NSW RURAL FIRE SERVICE

Your reference: MP 10_0204 MOD 6
Our reference: D17/3384
DA17092609466 GB
ID:109466/103075/5

19 January 2018

Proposal: Catherine Hill Bay development - proposed modification to Stage 7

drawing title:
**"BEACHES"
CATHERINE HILL BAY
STAGE 7
LOT LAYOUT COMPARISON**

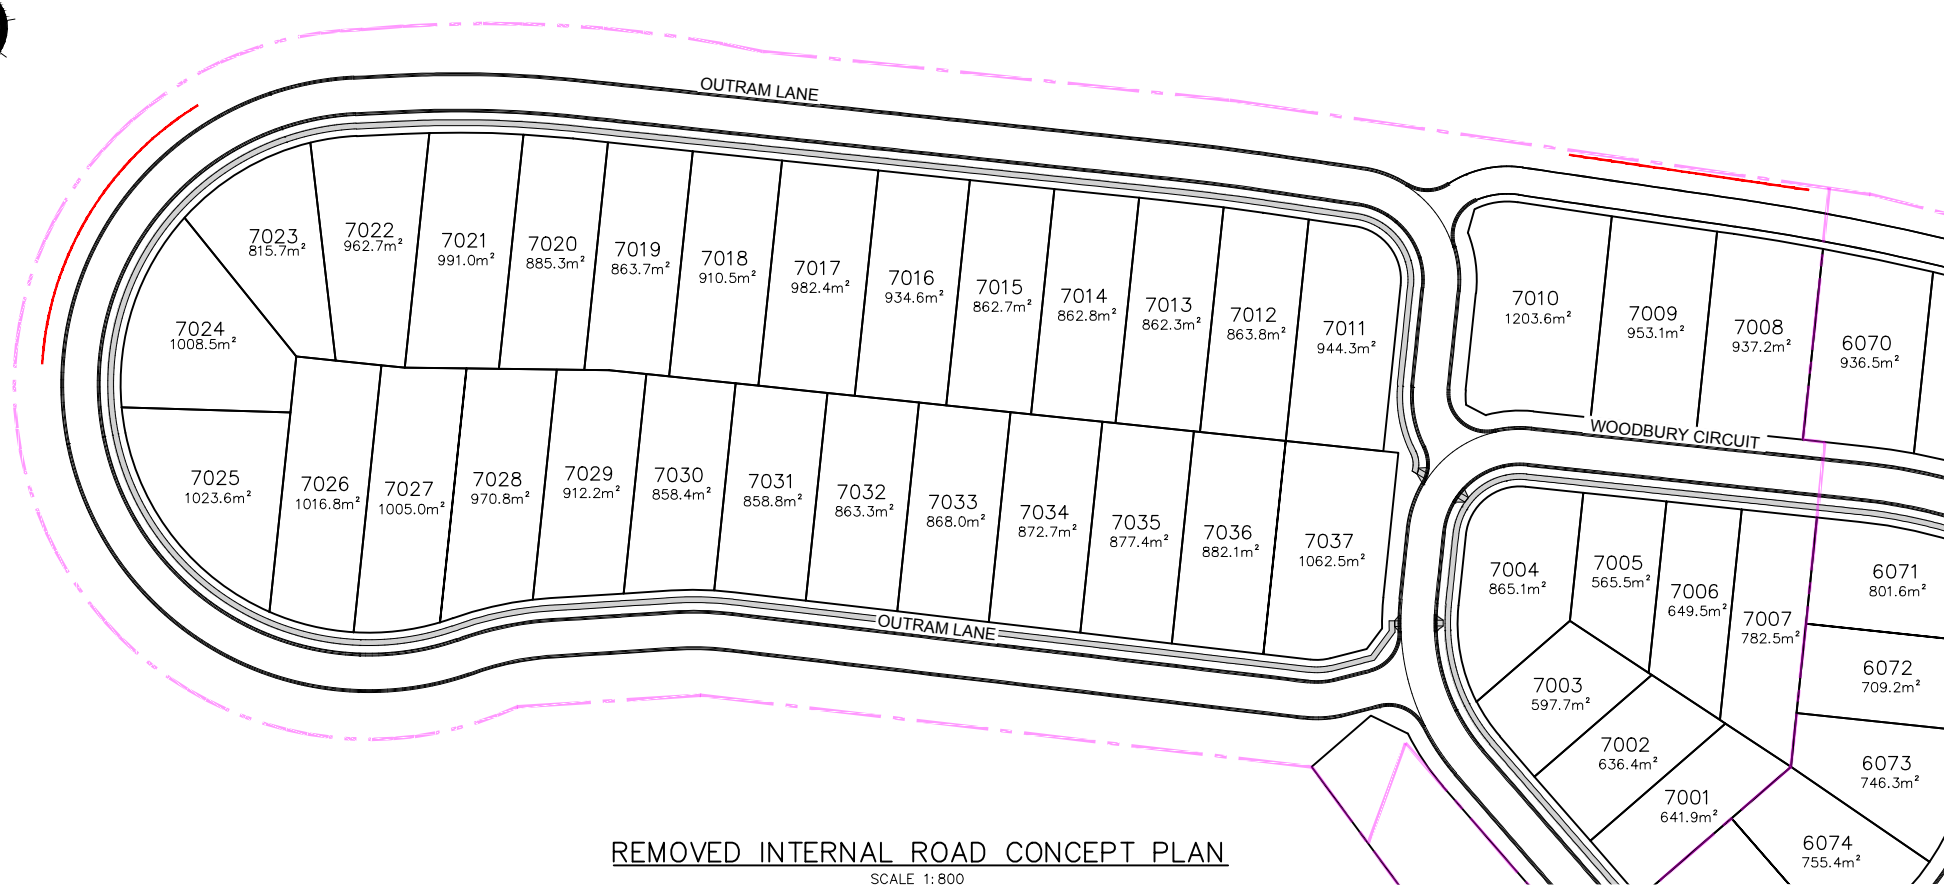
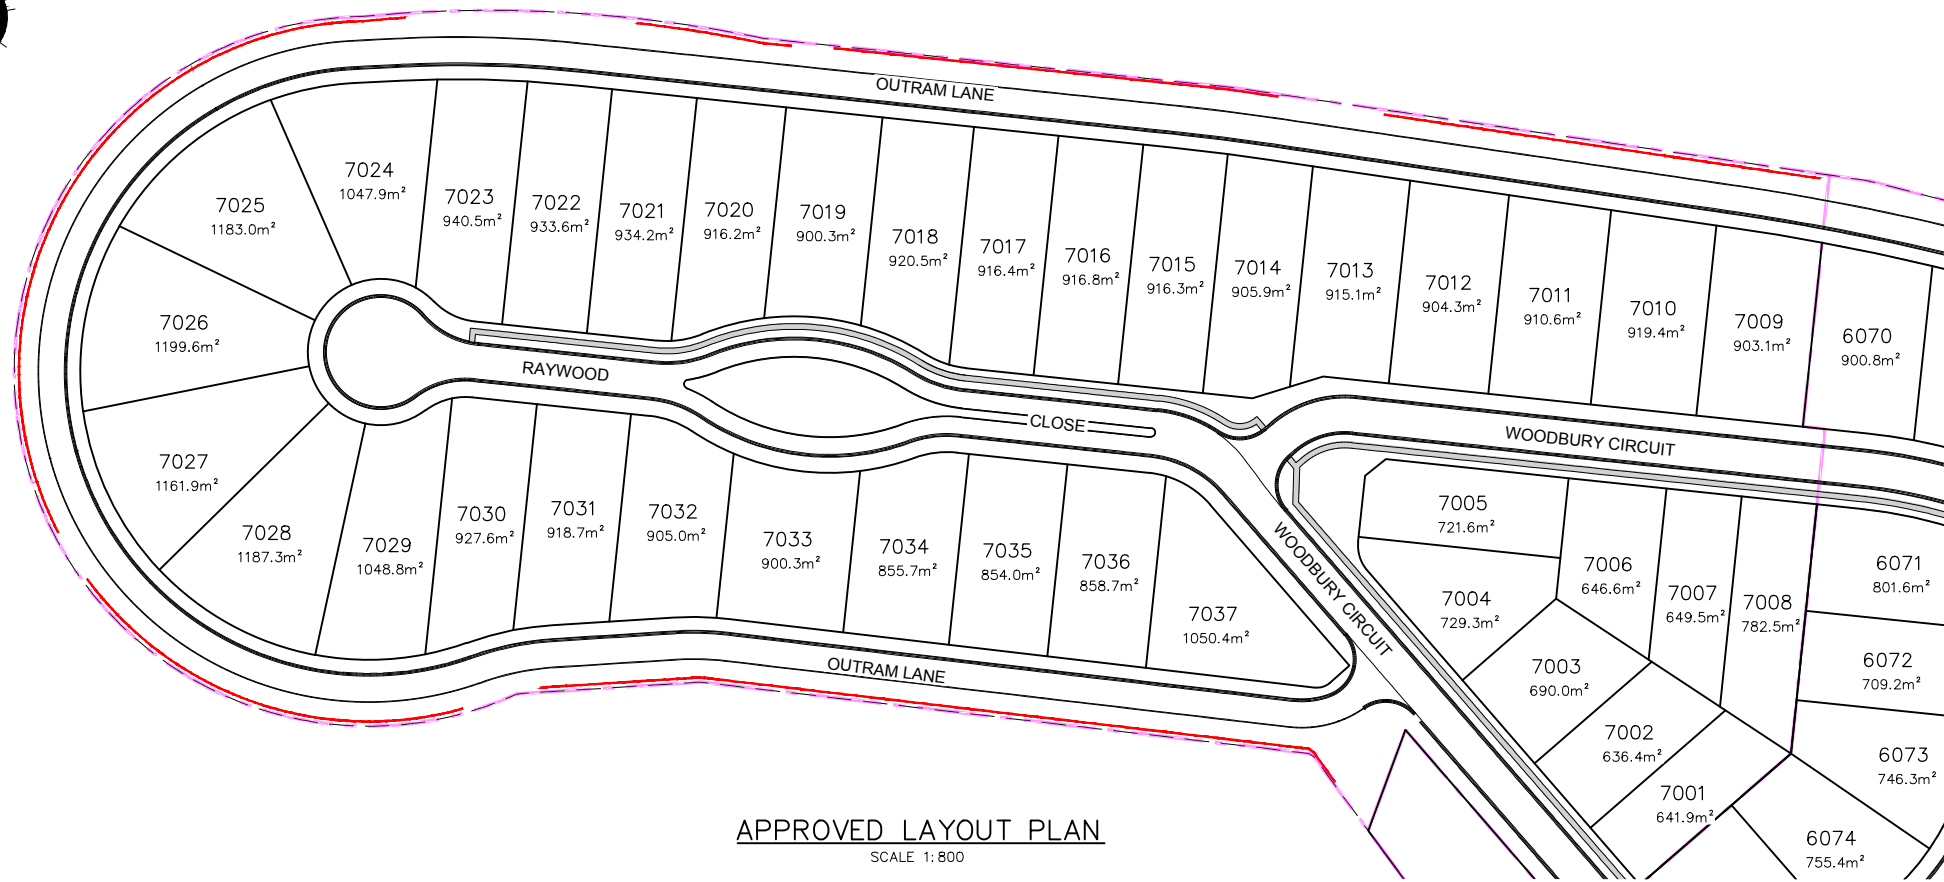
The New South Wales Rural Fire Service (NSW RFS) has reviewed the proposal and based upon an assessment of the information and plans provided, the NSW RFS raises no objection to the proposed modification subject to the following additional condition. It is noted that Raywood Circuit lies within a road reserve of 22.5 metres.

1. Proposed road, Raywood Circuit, shall comply with section 4.1.3 (1) of *Planning for Bush fire Protection 2006*, and shall have a minimum carriageway width of 8 metres kerb to kerb.
